May 21, 2014

**Subject: 421 Warren Avenue
Final Site Plan Application/Delegated Review Stormwater
Comment Response #2**

DATE: NOVEMBER 2013
SCALE: 1" = 30'
JOB NO.: SP-M104
FILE NAME: SP-M104-SITE
SHEET C-30

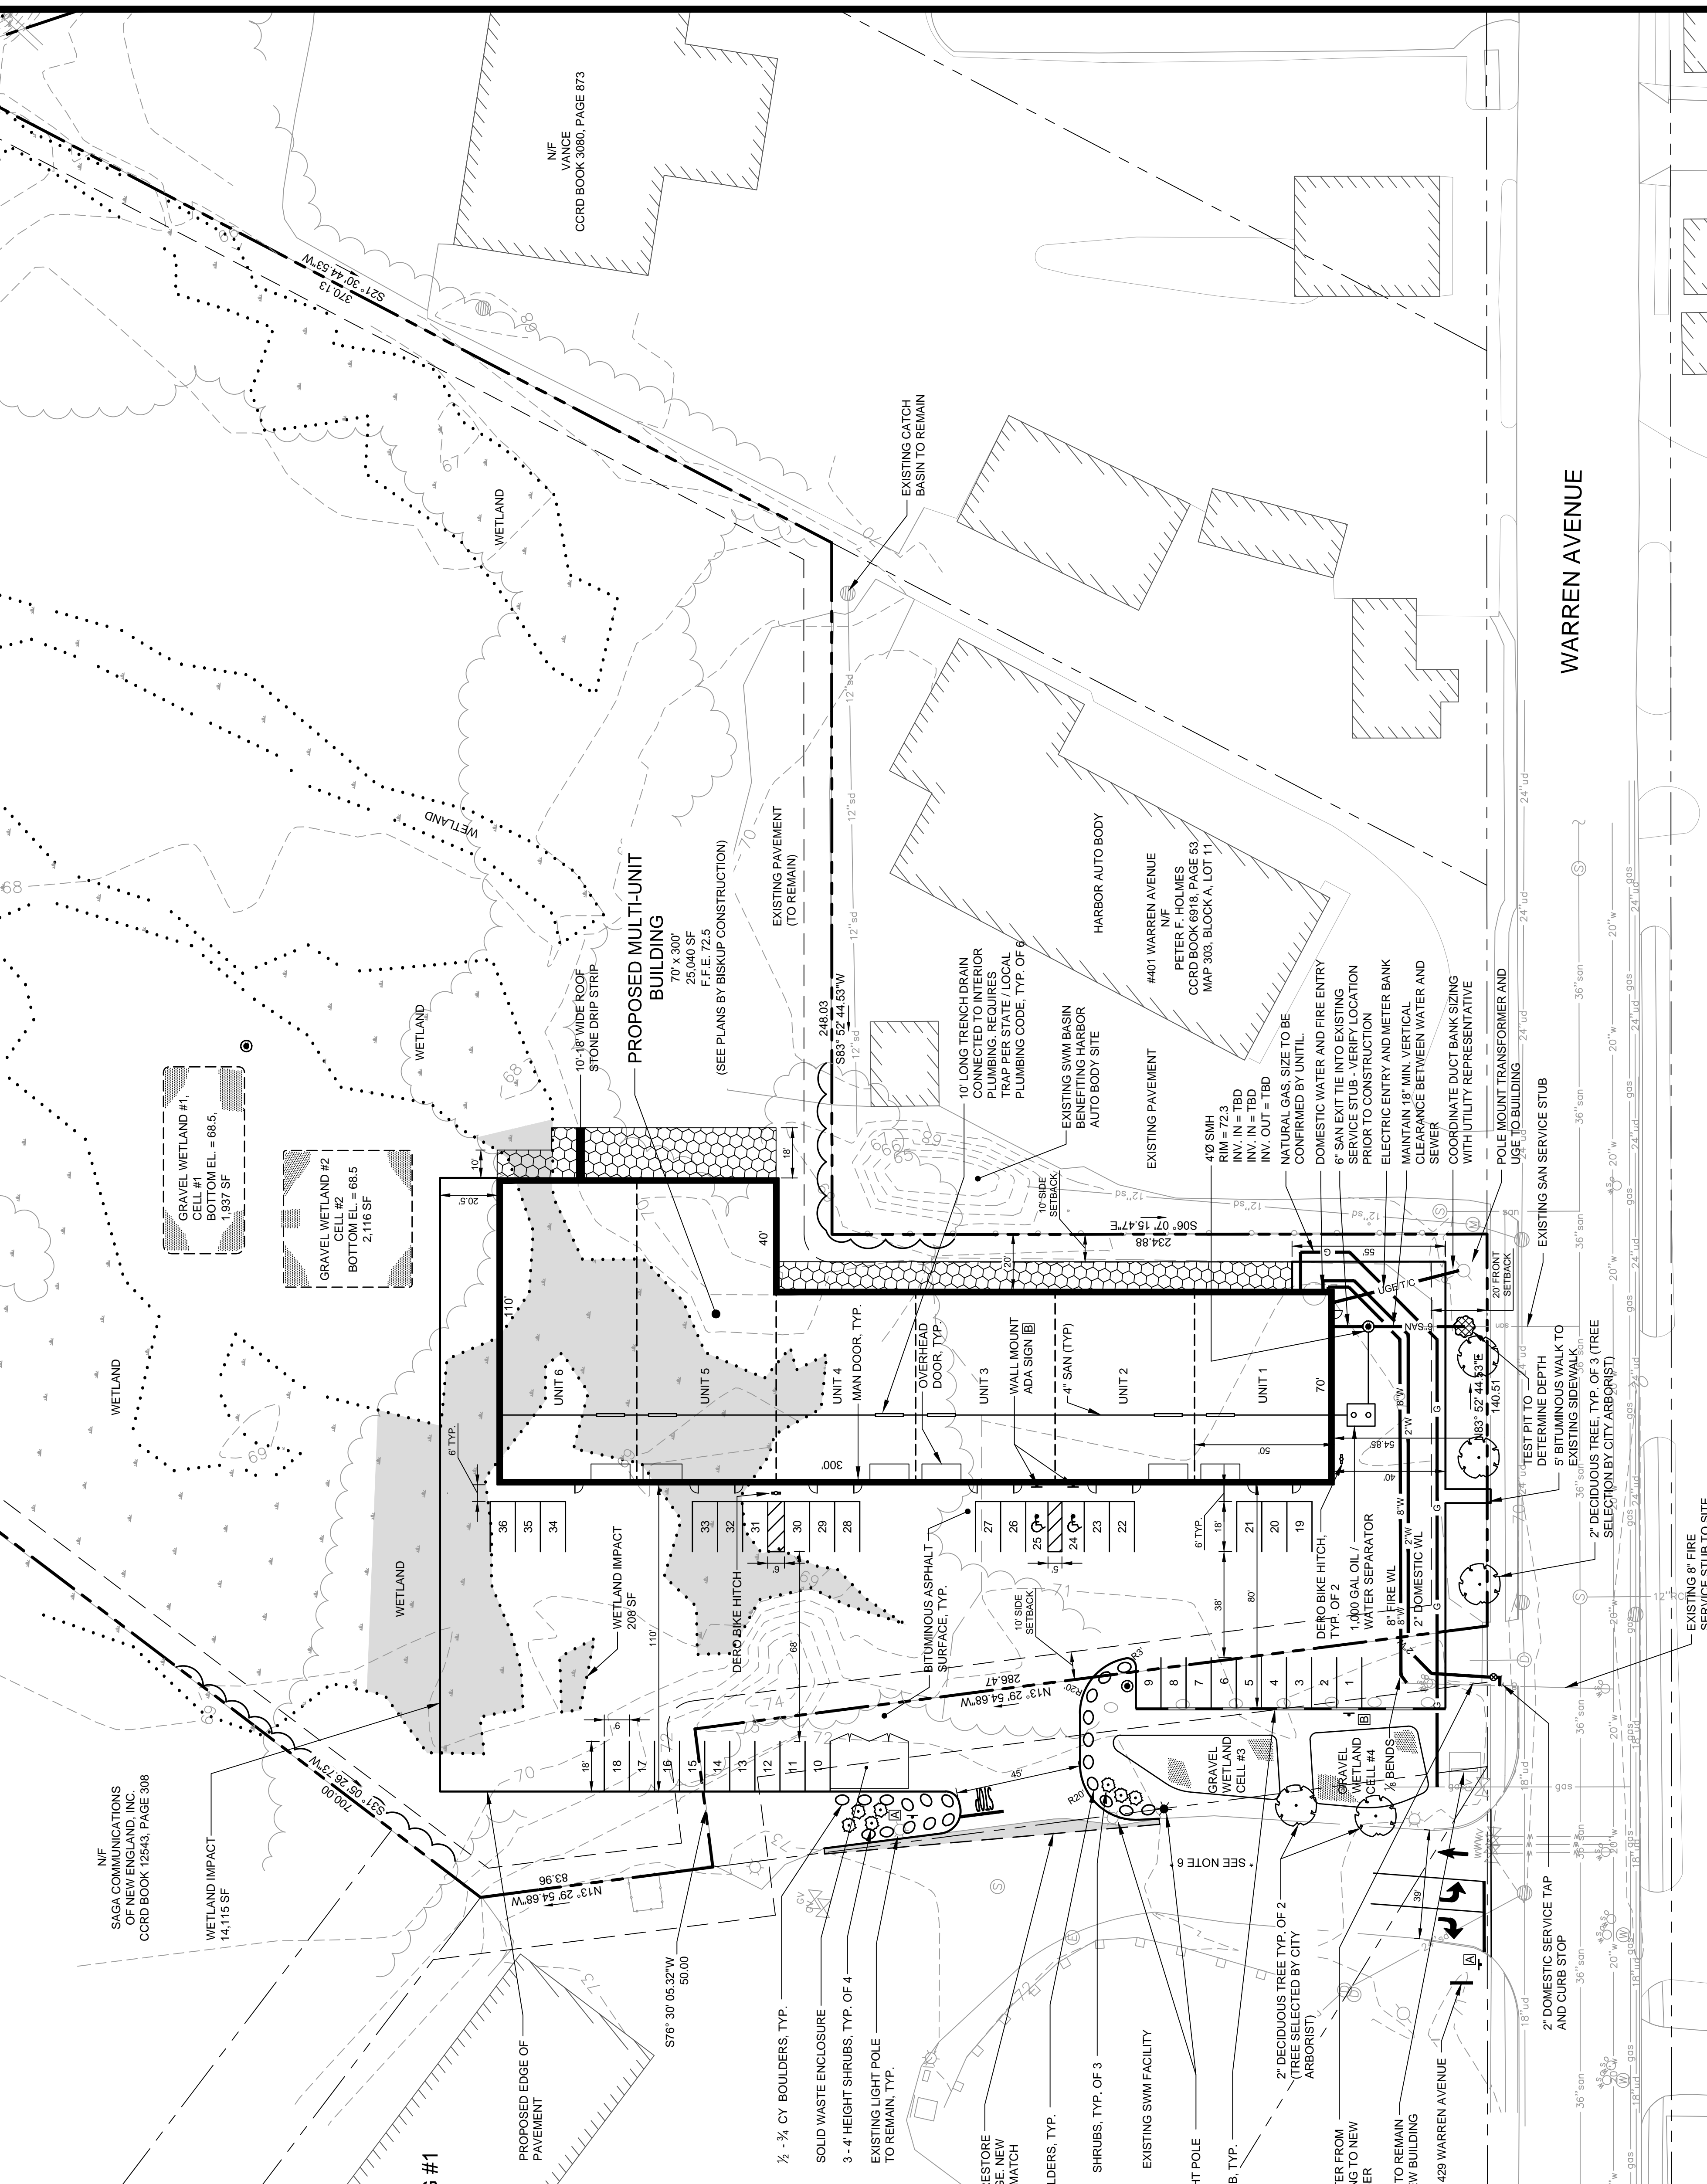
Comment 1: Why is the 20 feet alongside the building needed? (north side)

Comment 2: What do trucks do if cars are parked in parking spaces?

Comment 4: All of these questions relate to the strong staff view that the shape and extent of the paved area is not necessarily supporting the proposed industrial/commercial function intended and that the paved area in the corner and along the north side (where it takes the trees/wetland) is un-necessary as its not used for parking nor truck maneuvering.

Response: The applicant intends to use this area for snow plowing and parking of a snowplow during the winter. Having operated the property at 429 Warren Avenue, it is the applicant's experience that having this small paved area adjacent the building is beneficial.

Response: The applicant has experience with operations of a similar facility at 429 Warren Avenue, thus they know that the majority of larger semi-trailer truck visits are made when the parking area is empty or partially occupied. On occasion they may cone off sections for deliveries. The applicant has considered the layout closely with their experience and operational needs of similar sites he owns in Portland and previously owned in Lewiston. Based on the anticipated tenant uses for the building, the applicant is firmly of the opinion that the proposed layout is required and will be satisfactory for the intended use.

Response: The applicant's site development layout has undergone a series of revisions and cut backs to meet natural resource impact thresholds among other things. On this basis we are satisfied as to the layout and will present to the Planning Board the layout as currently submitted, despite possible continued staff reservation on size and impervious area. We note that the site still only constitutes less than a 10% development area of the 48 acres owned by the applicant. This, along with the design measures for stormwater being fully compliant with local and State regulations, seems sufficient evidence to support the applicant's goal of site plan approval on the plan as designed.
